Prior Notification for Permitted Development

Schedule 2 Part 3 Class MA

Development: Prior Approval under Schedule 2, Part 3, Class MA for the change of use from a business (Class E) to 3 No flats (C3).
Location: 80-82 High Street Littlehampton BN17 5DX

PROPOSED FIRST FLOOR PLAN

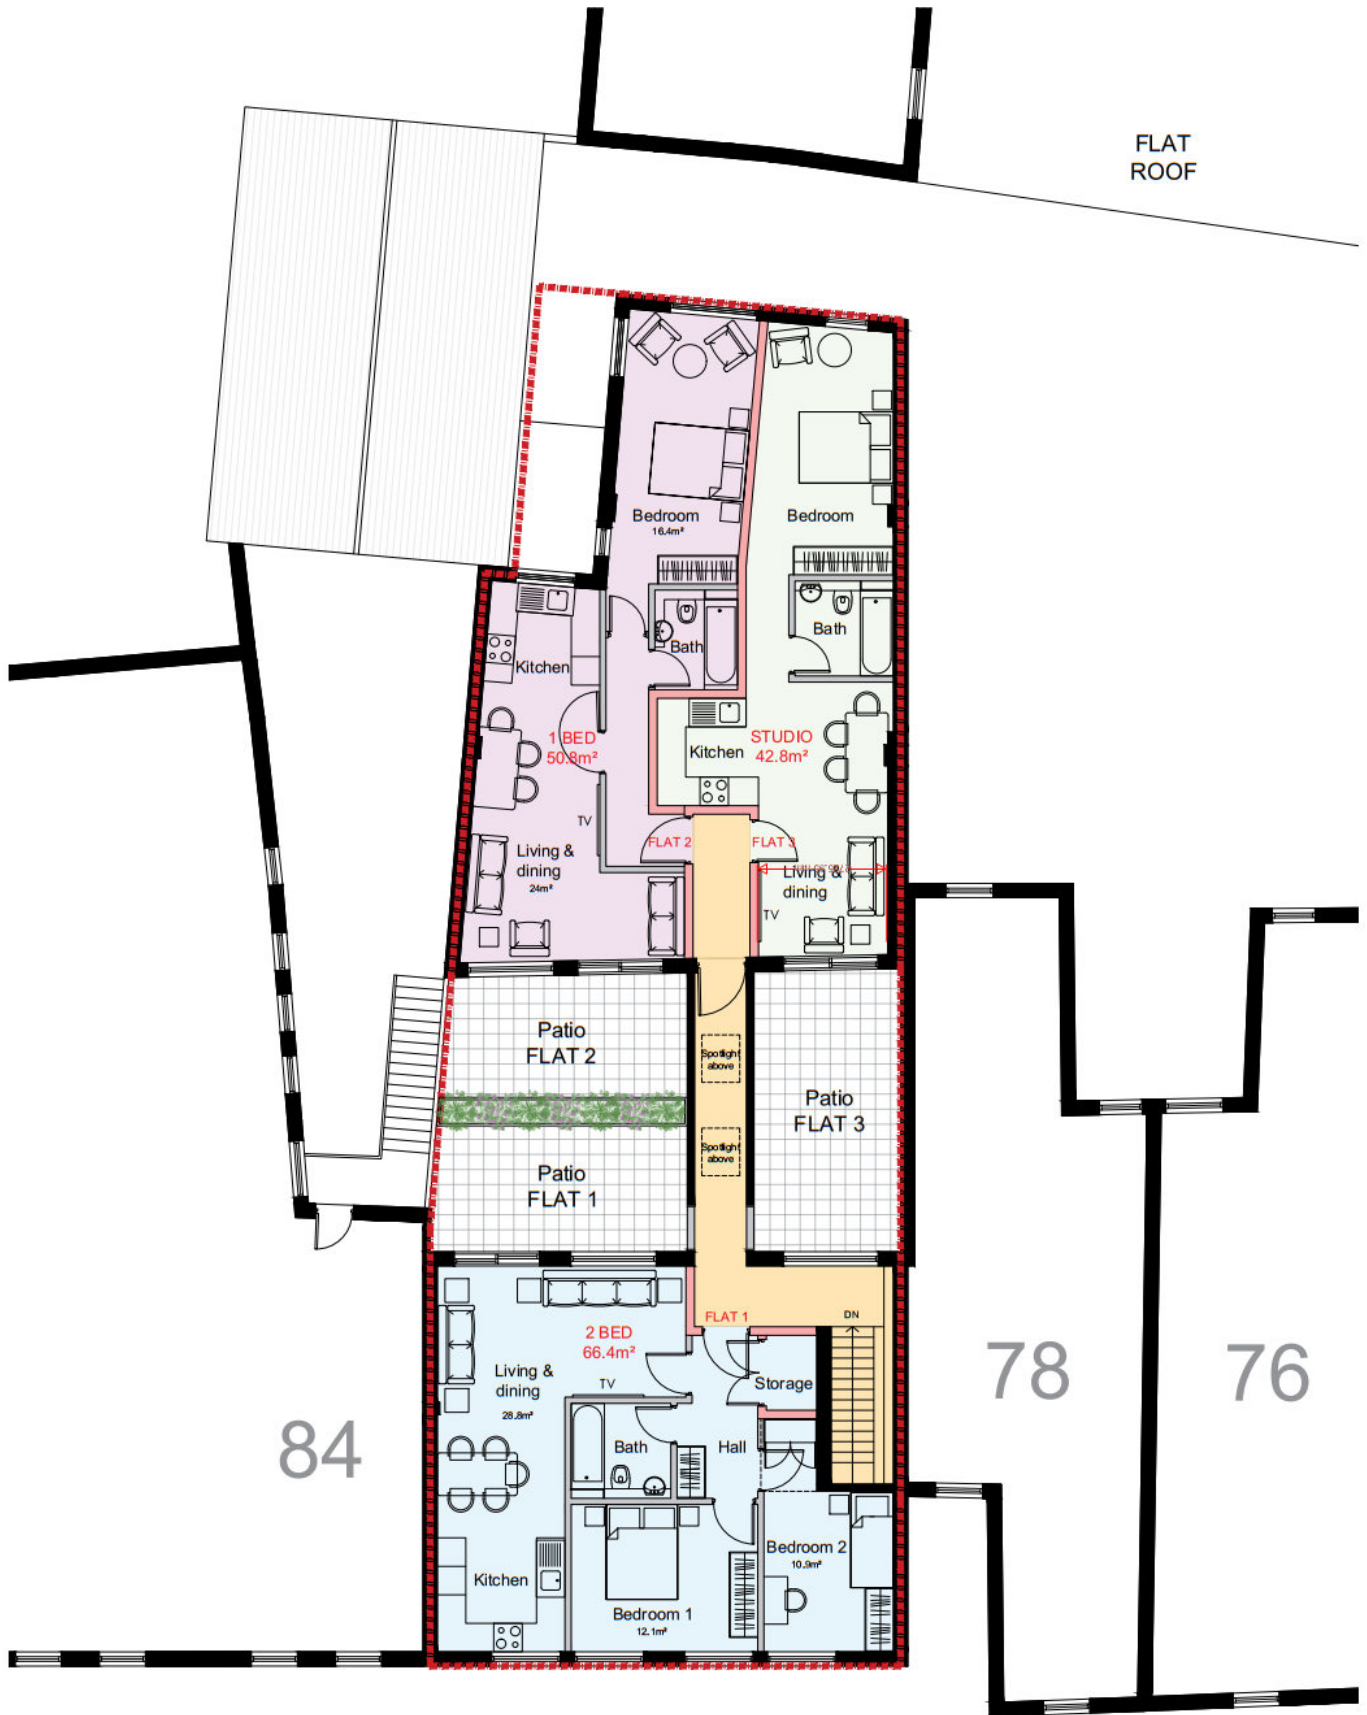
On the proposed floor plans, please provide measurements of all windows and doors.
